# BUILDING PERMIT

Located At 75 INDUSTRIAL WAY

Job ID: 2012-09-4952-ALTCOMM

has permission to make 920 sq ft of office space within the warehouse area as per plans provided that the person or persons, firm or corporation accepting this permit shall comply with all of the provisions of the Statutes of Maine and of the Ordinances of the City of Portland regulating the construction, maintenance and use of the buildings and structures, and of the application on file in the department.

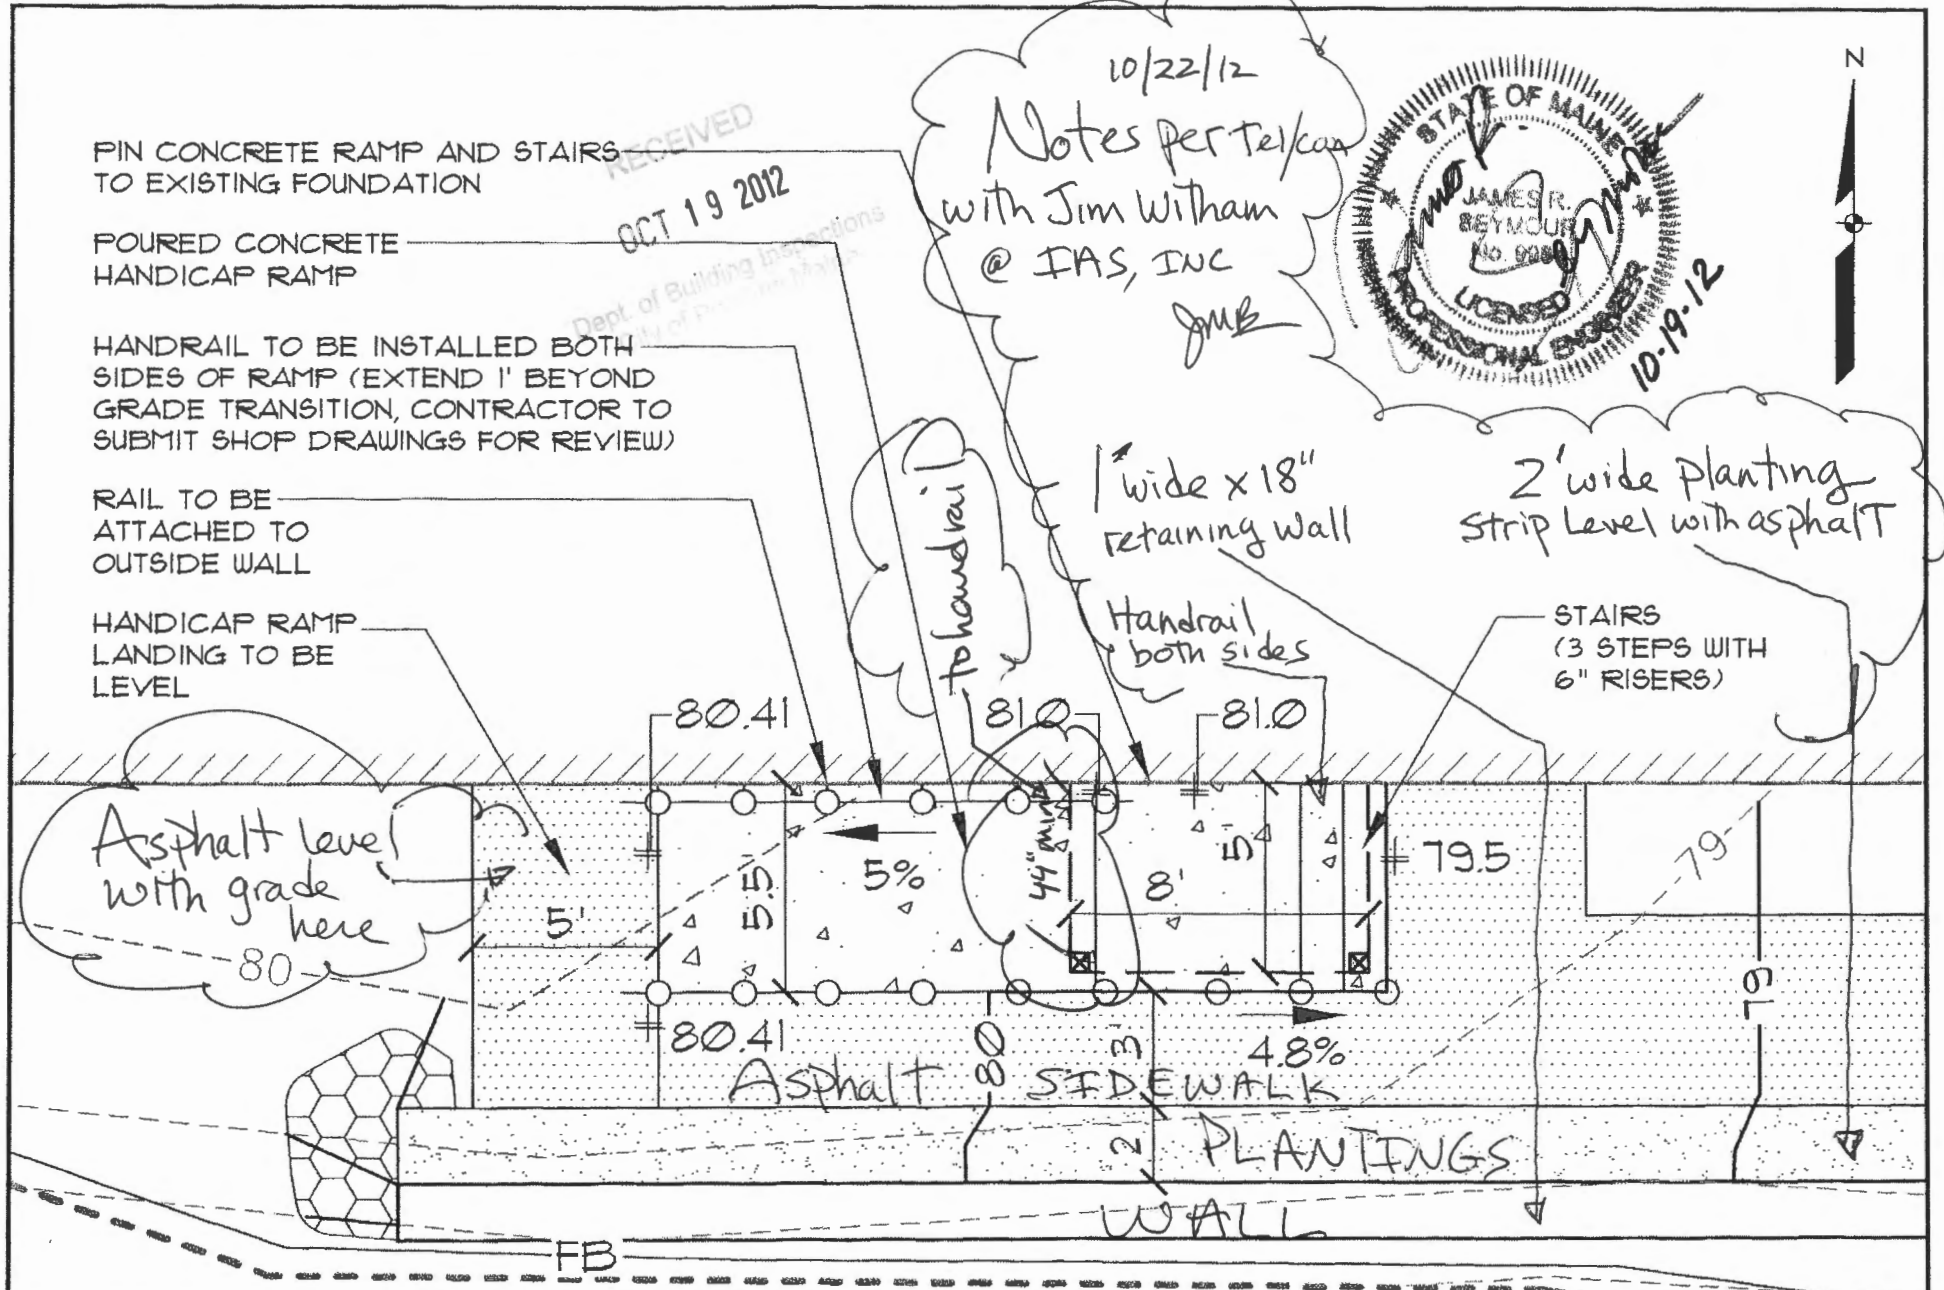
**The exterior stair and ramp are new and shall comply with the requirements for new. Both shall have proper handrails on both sides.**
